SUBJECT: Sky Sweeper Short Plat SP-07-153

Thank you for the opportunity to comment on the Sky Sweeper short plat of 40 acres into 4 lots, proposed by D&H Ranch Inc [SP-07-153]. We have reviewed the application and have the following comments.

SKY SWEEPER SHORT PLAT
 PART OF SECTION 36, T. 18 N., R. 17 E., W.M.
 KITITAS COUNTY, WASHINGTON

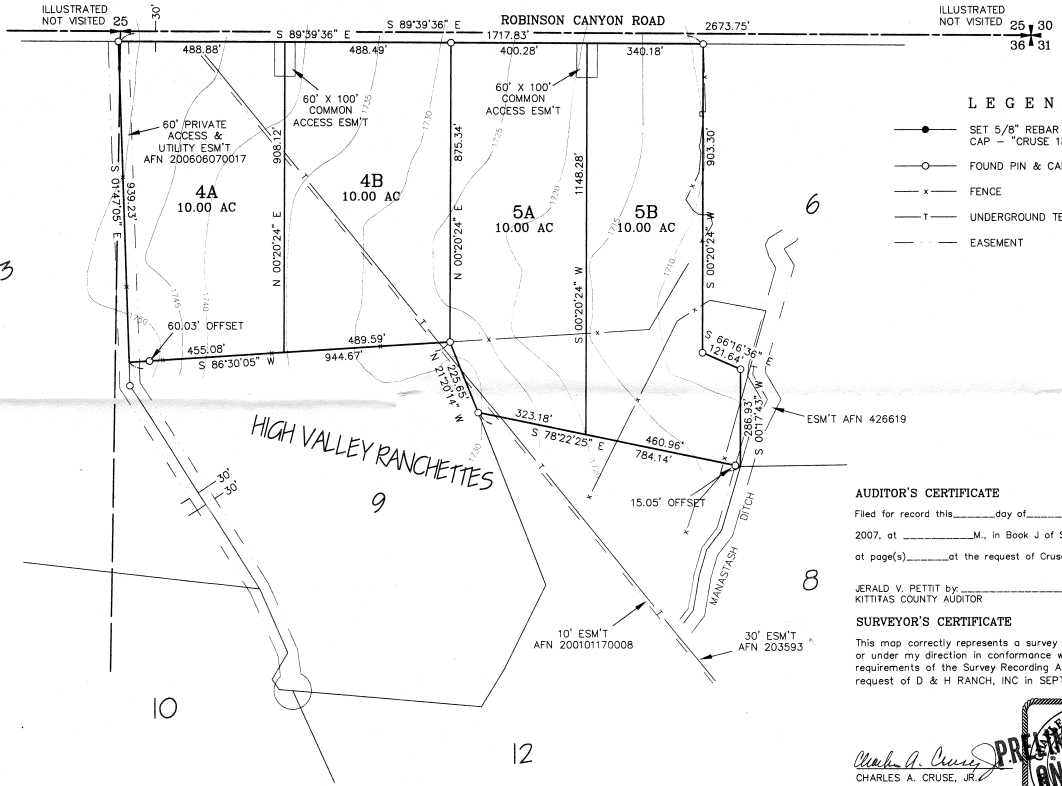
1. **Access:** Lots 4A & 4B and 5A & 5B may be accessed through joint-use driveways. If Lot 4A is accessed through the 60' easement, the easement access must be improved to meet the requirements of a Low Density Private Road, end in a cul-de-sac, and be certified prior to receiving a building permit. See requirements below.

4. Private Road Improvements: If Lot 4A is accessed from the 60' access easement, the access shall be constructed as a Low-Density Private Road. See Kittitas County Road Standards, 9/6/05 edition.

- a. Access easements shall be a minimum of 60' wide. The roadway shall have a minimum width of 20', with 1' shoulders, for a total width of 22'.
 - b. Minimum centerline radius will be 60'.

The potable water plat note is incorrect (plat note #8). Please replace the plat note with the following:

"The approval of this division of land includes no guarantee that there is a legal right to withdraw groundwater within the land division. The approval of this division of land provides no guarantee that use of water under the ground water exemption (RCW 90.44.050) for this plat or any portion thereof will not be subject to curtailment by the Department of Ecology or a court of law. "

Please also include the following plat note:

"Metering will be required on all residential well connections and metering results shall be recorded in a manner consistent with Kittitas County and Washington State Department of Ecology requirements."
